Located At 56 HAMMOND ST

Job ID: 2012-06-4359-CH OF USE

has permission to Demo existing structure, build new 3 story, 3 unit apt., 1 of 2 on Parcel B, single exit enclosure provided that the person or persons, firm or corporation accepting this permit shall comply with all of the provisions of the Statues of Maine and of the Ordinances of the City of Portland regulating the construction, maintenance and use of the buildings and structures, and of the application on file in the department.

**Jeanie Bourke - RE: 56 Hammond St BP#2012-06-4358 & 4359 plan review comments**

3~THIRD FLOOR PLAN- 1/4 in = 1 ft

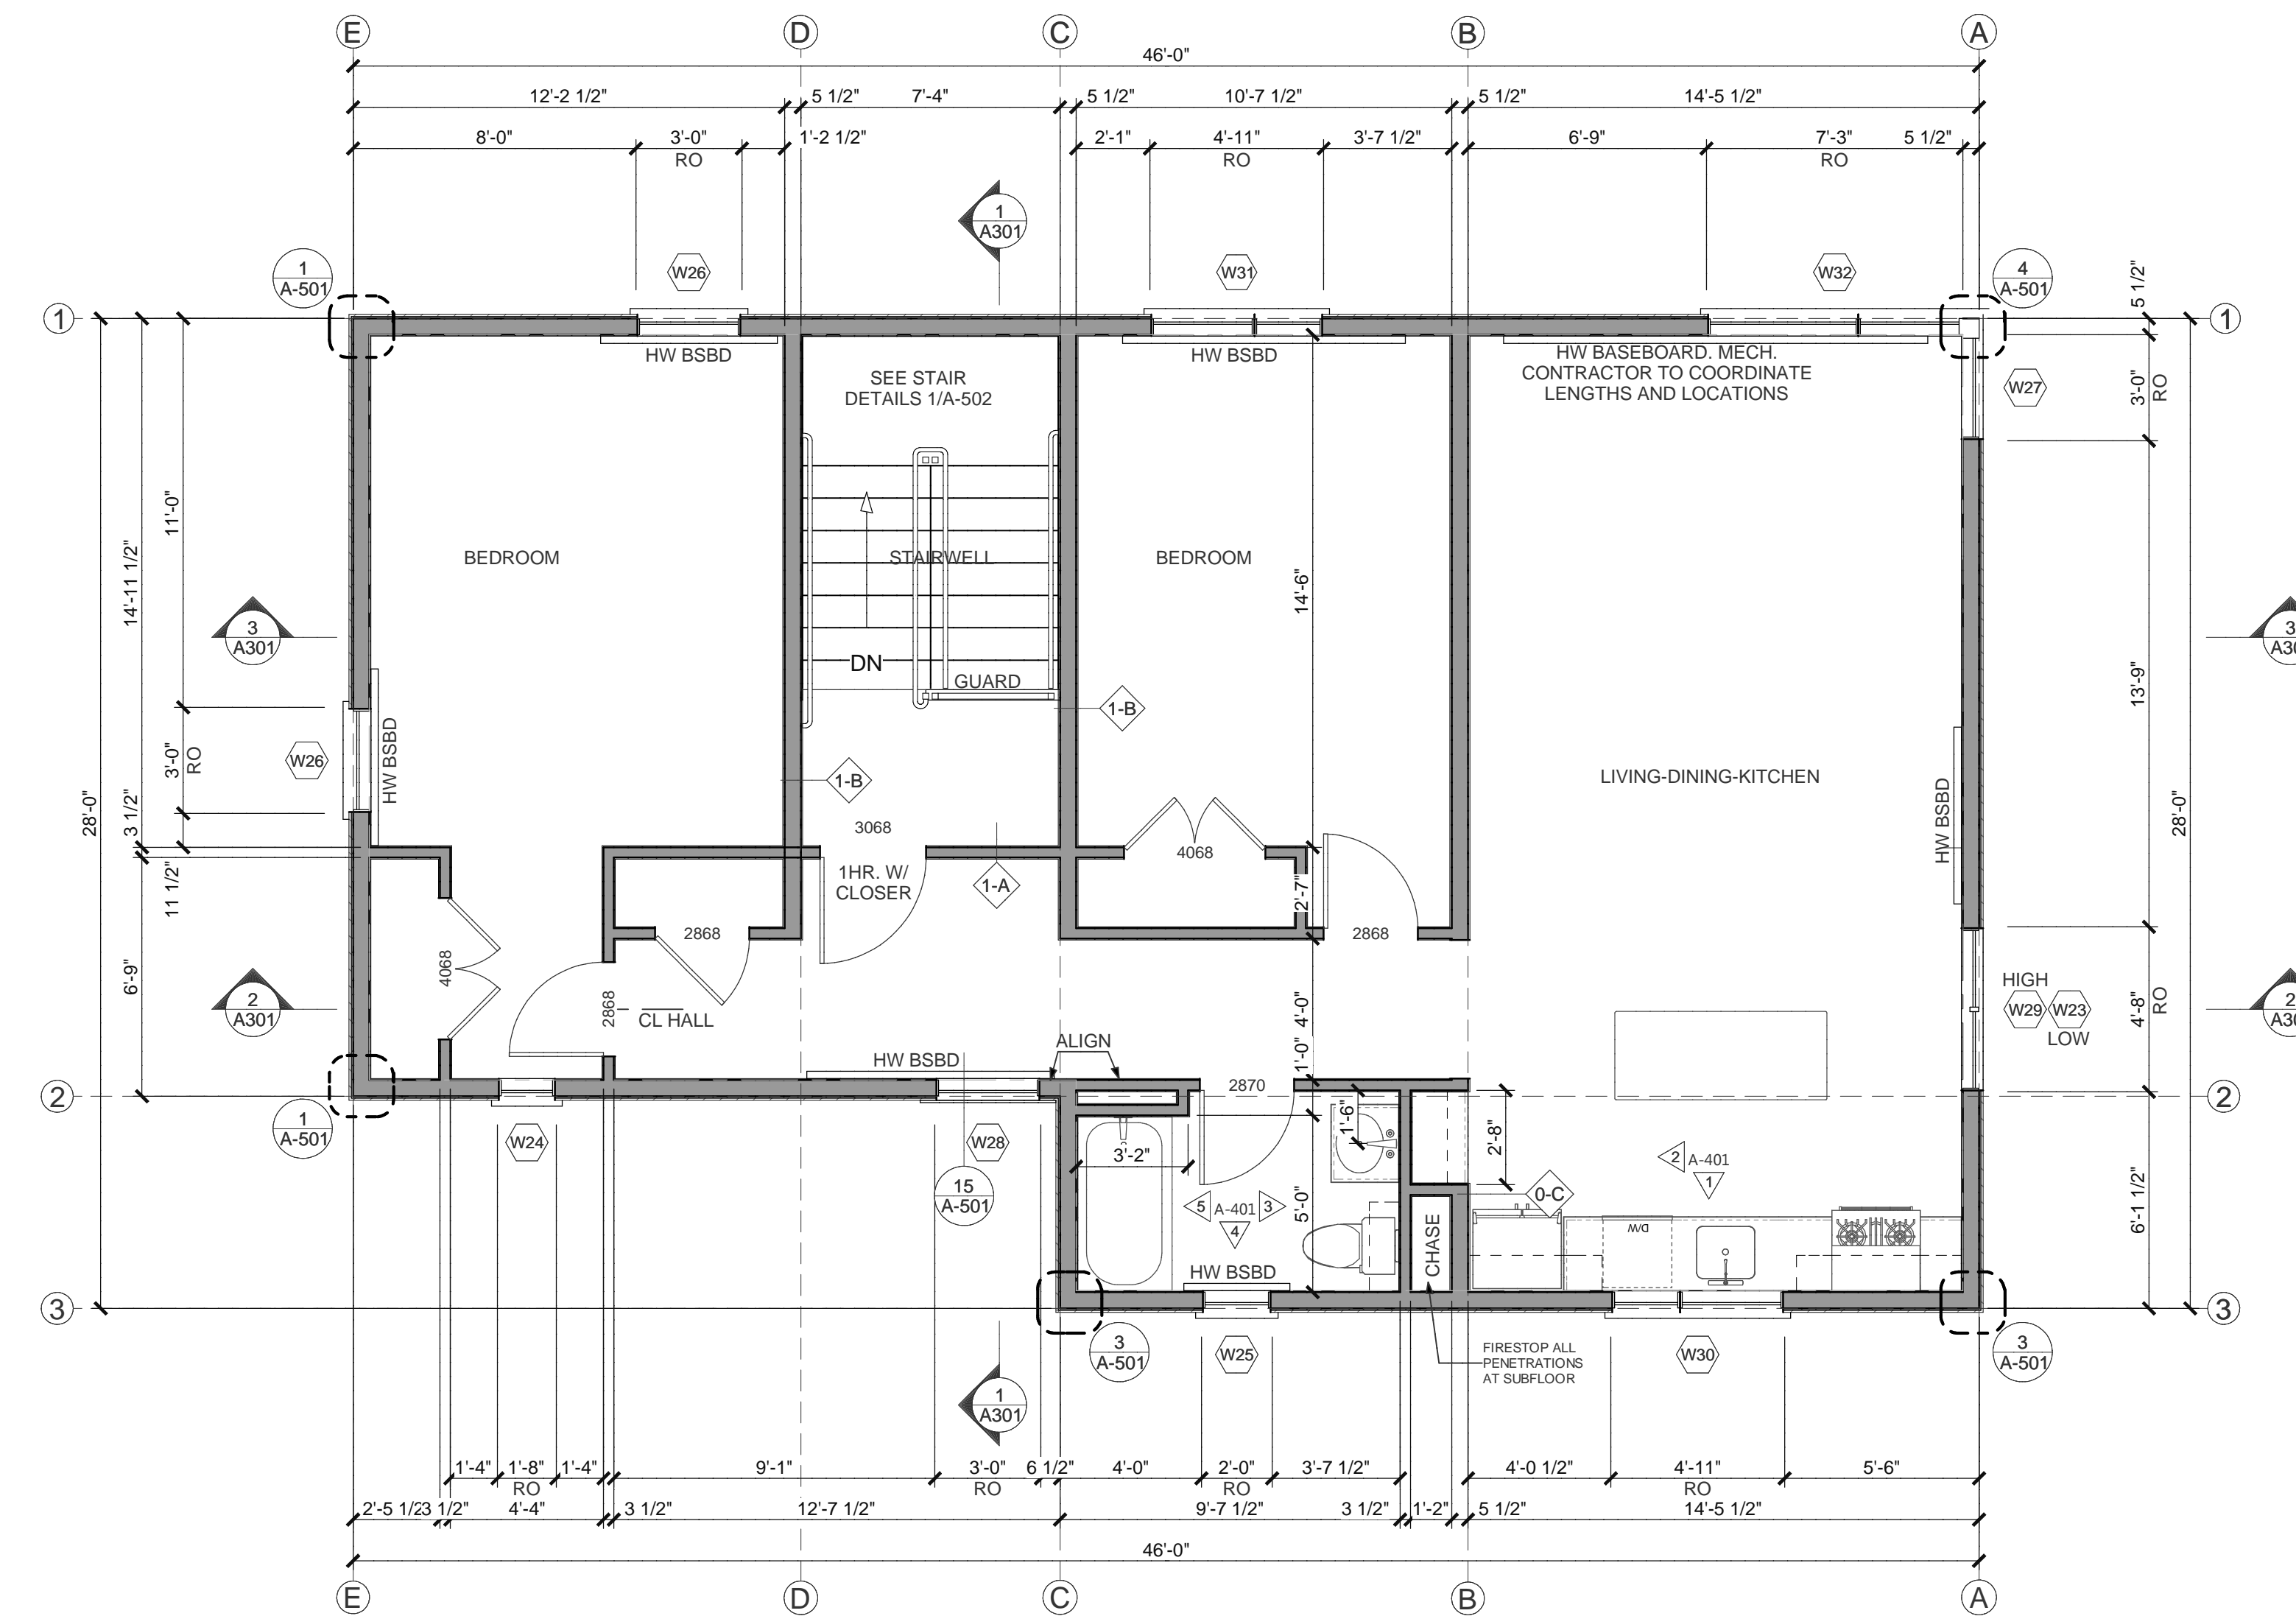
· Provide a 1 hour rated wall assembly for the mechanical chase 0-C or clarify if the penetrations are individual and sealed at each floor, thus not a true chase enclosure

*The penetrations are sealed at each floor. That is the intention of the note "FIRESTOP ALL PENETRATIONS AT SUBFLOOR" included on sheets A101 & A102.*

1~Stair Section - 1/2 in = 1 ft

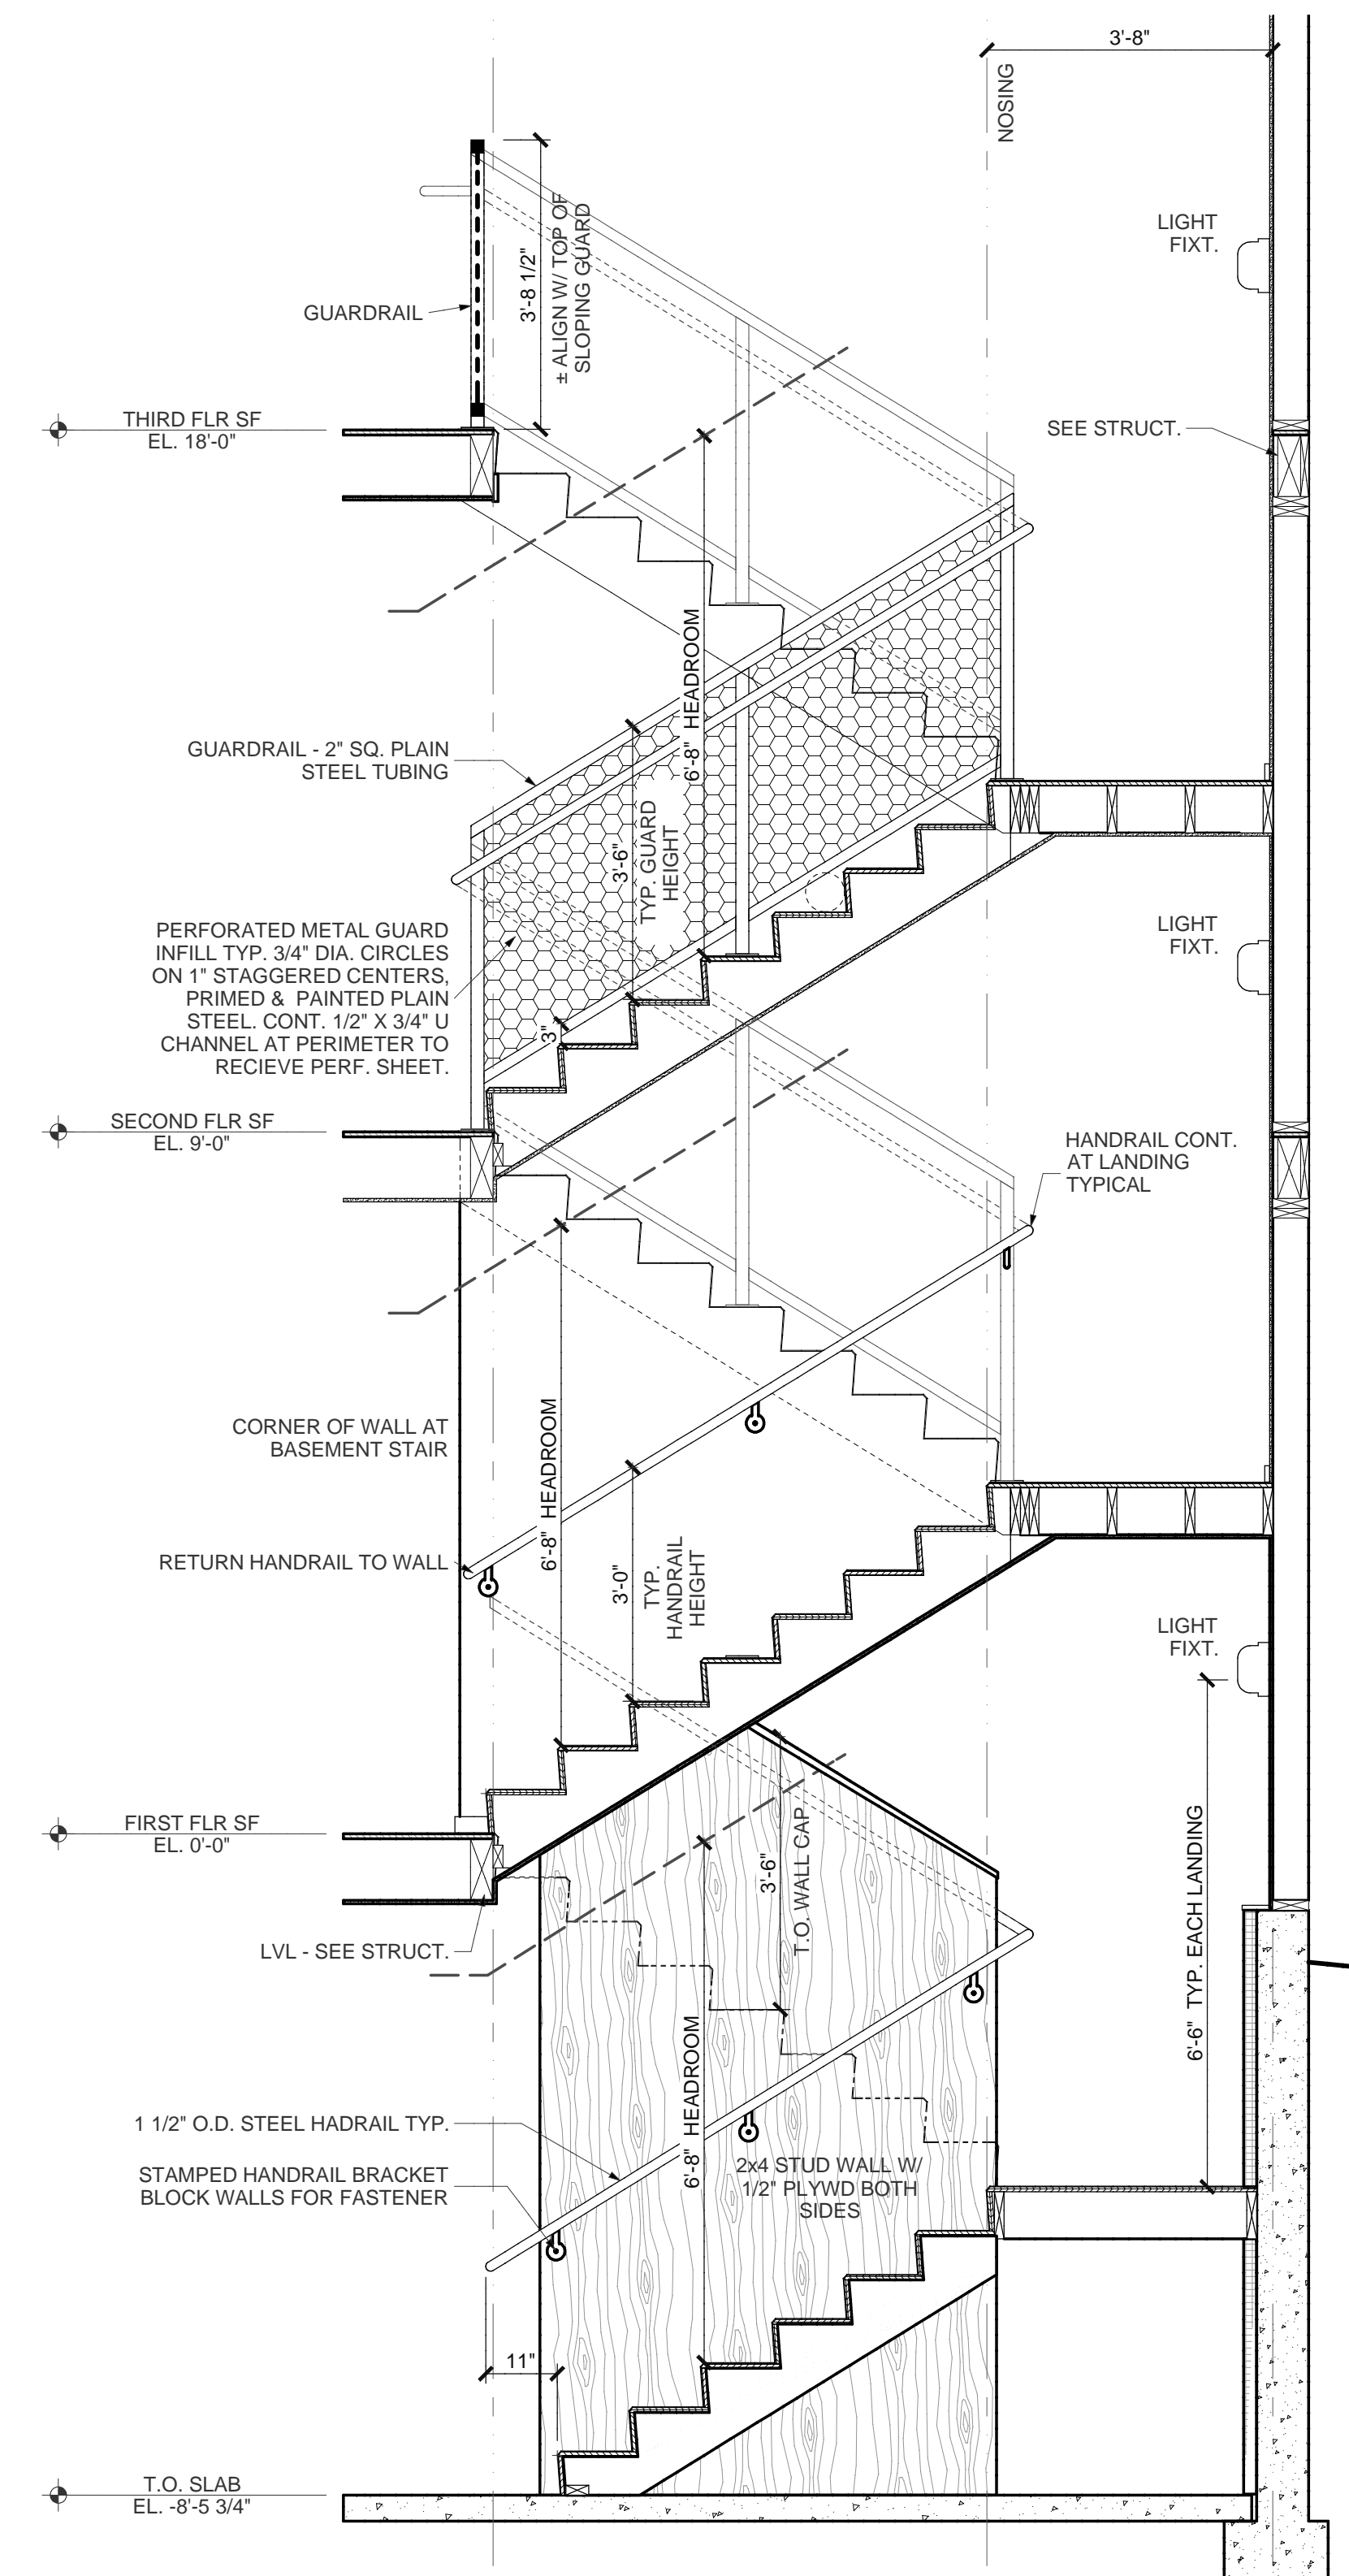
· Provide a wall section for 1-B continuity at the connection of the stair framing

*See attached SK-3.*
